From: Sarah Featherstone 
Sent: 22 October 2019 11:57
To: Anita Gardner <Anita.Gardner@arun.gov.uk>
Cc: Martyn White <Martyn.White@arun.gov.uk>
Subject: Re: Thatch Cottage applications CM/42/19/PL and CM/43/19/L

Further to our previous email responding to the conservation officers comments on Thatch Cottage - I attach a drawing 02 305 which gives a detail of T&G board detail used on external wall cladding of new extension and includes the sliding door detail for windows 3, 4 & 5 in the new extension. Drawing 00 311 provides a detail of shutters to windows in flint walls, and whilst the elevation is of a window in Mill Cottage, the details are the same for all windows in flint walls Thatch i.e.. windows 6,7,8 ,9 &10.

We have read through Martyn White's (Conservation officer) comments on Thatch Cottage applications CM/42/19/PL and CM/43/19/L which are very useful and encouraging and we would like to confirm and respond as follows:

Detail of Pocket Sliding Door and Overlay Sliding Shutter

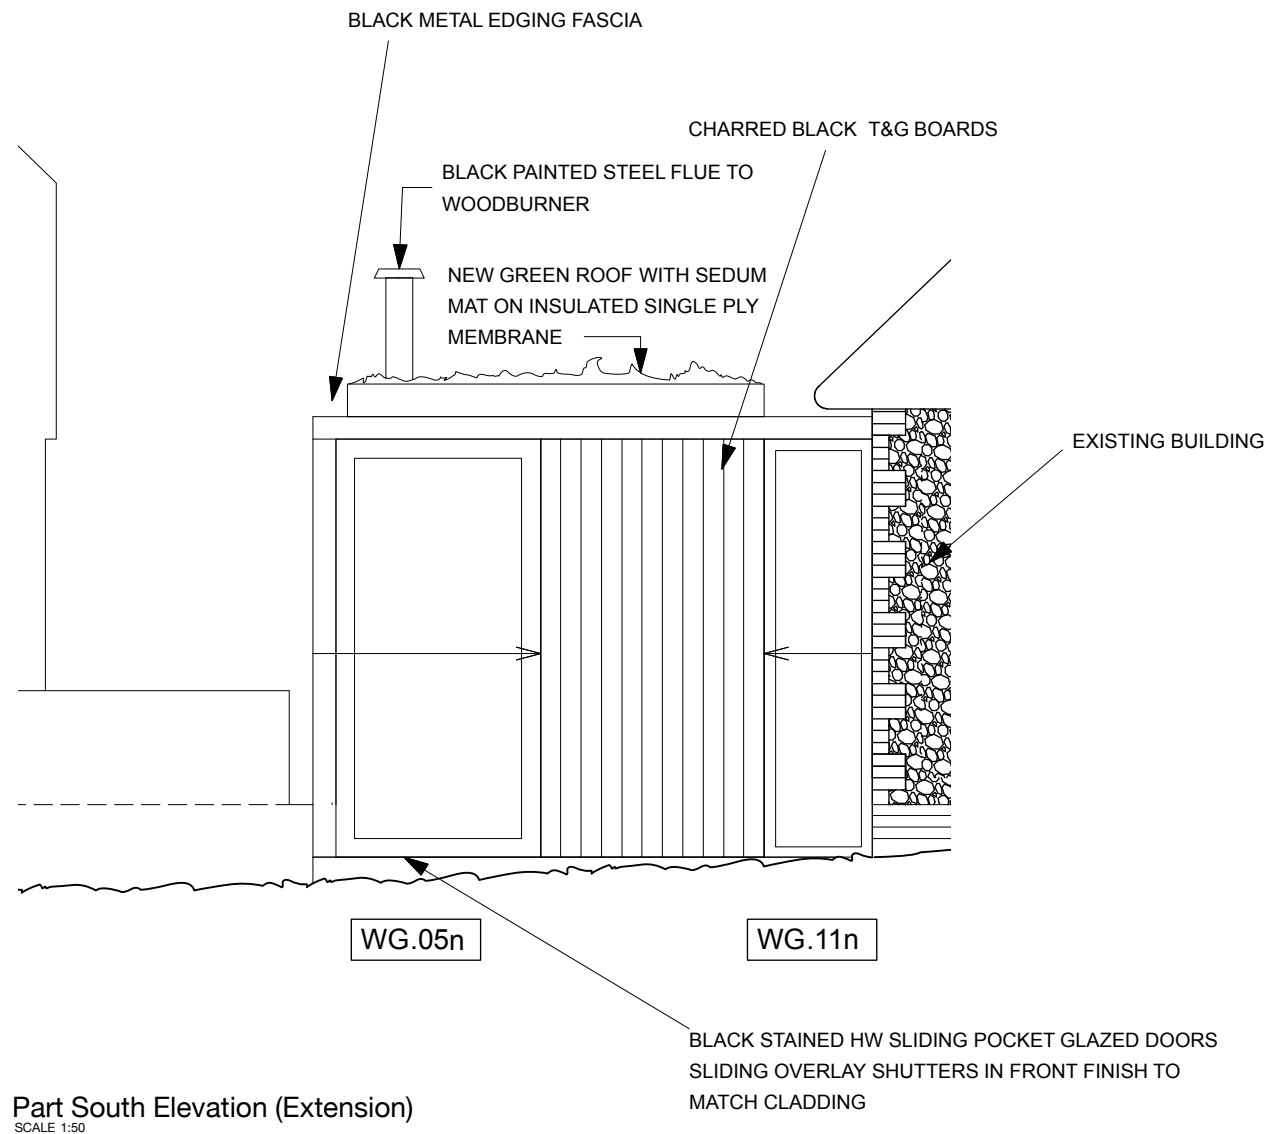
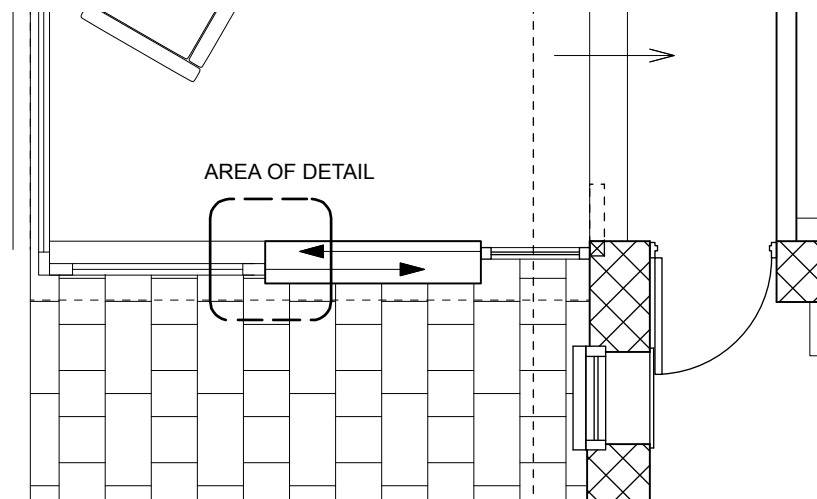
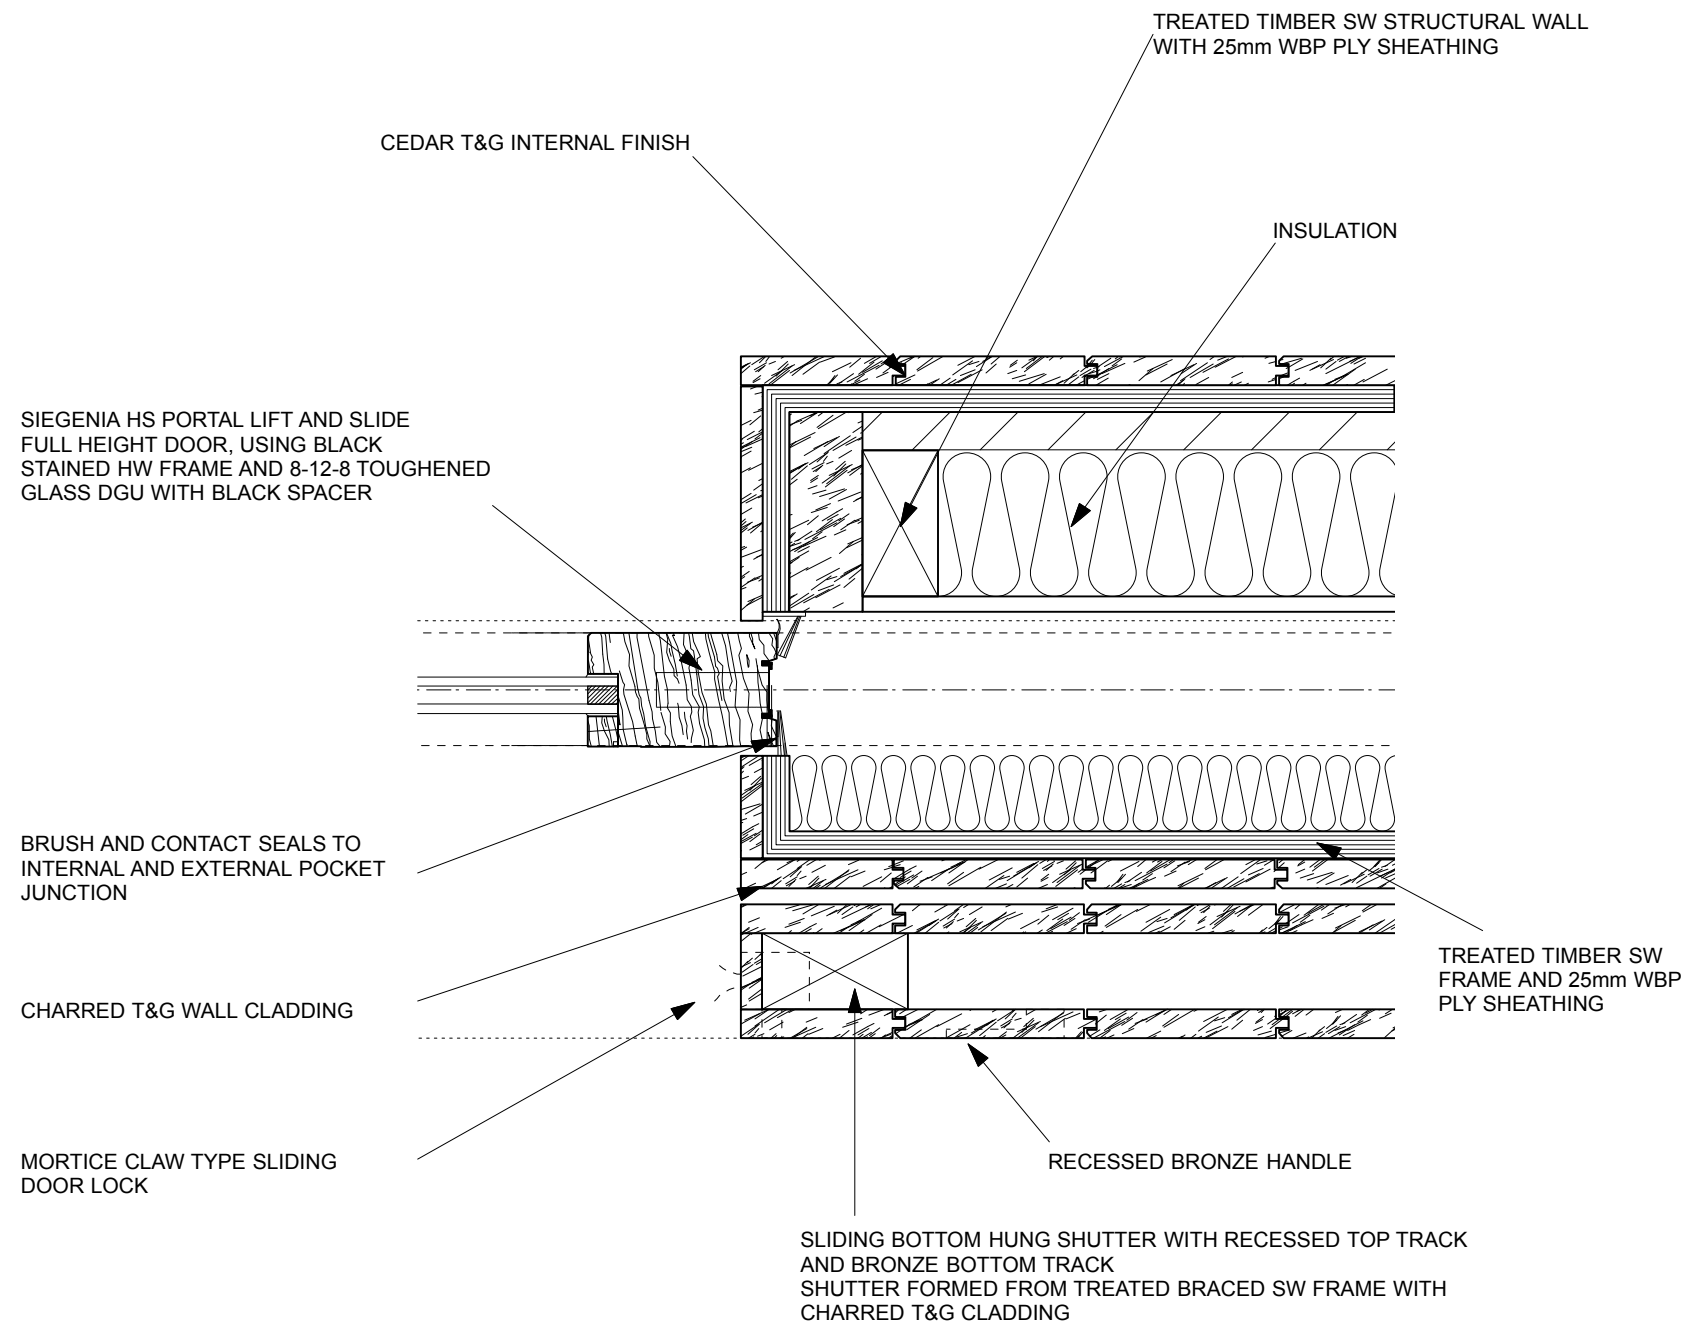
- T&G board detail used on external wall cladding of new extension
- Shutter details: Window 9 - proposed storm window - we stated "looks better if openings flush with window frame" — MW states "this is matter of detail" . We will provide a detail.

Windows 3 & 4 - we understand MW not clear how the shutters operate - they slide in front of external wall. We will provide detail.
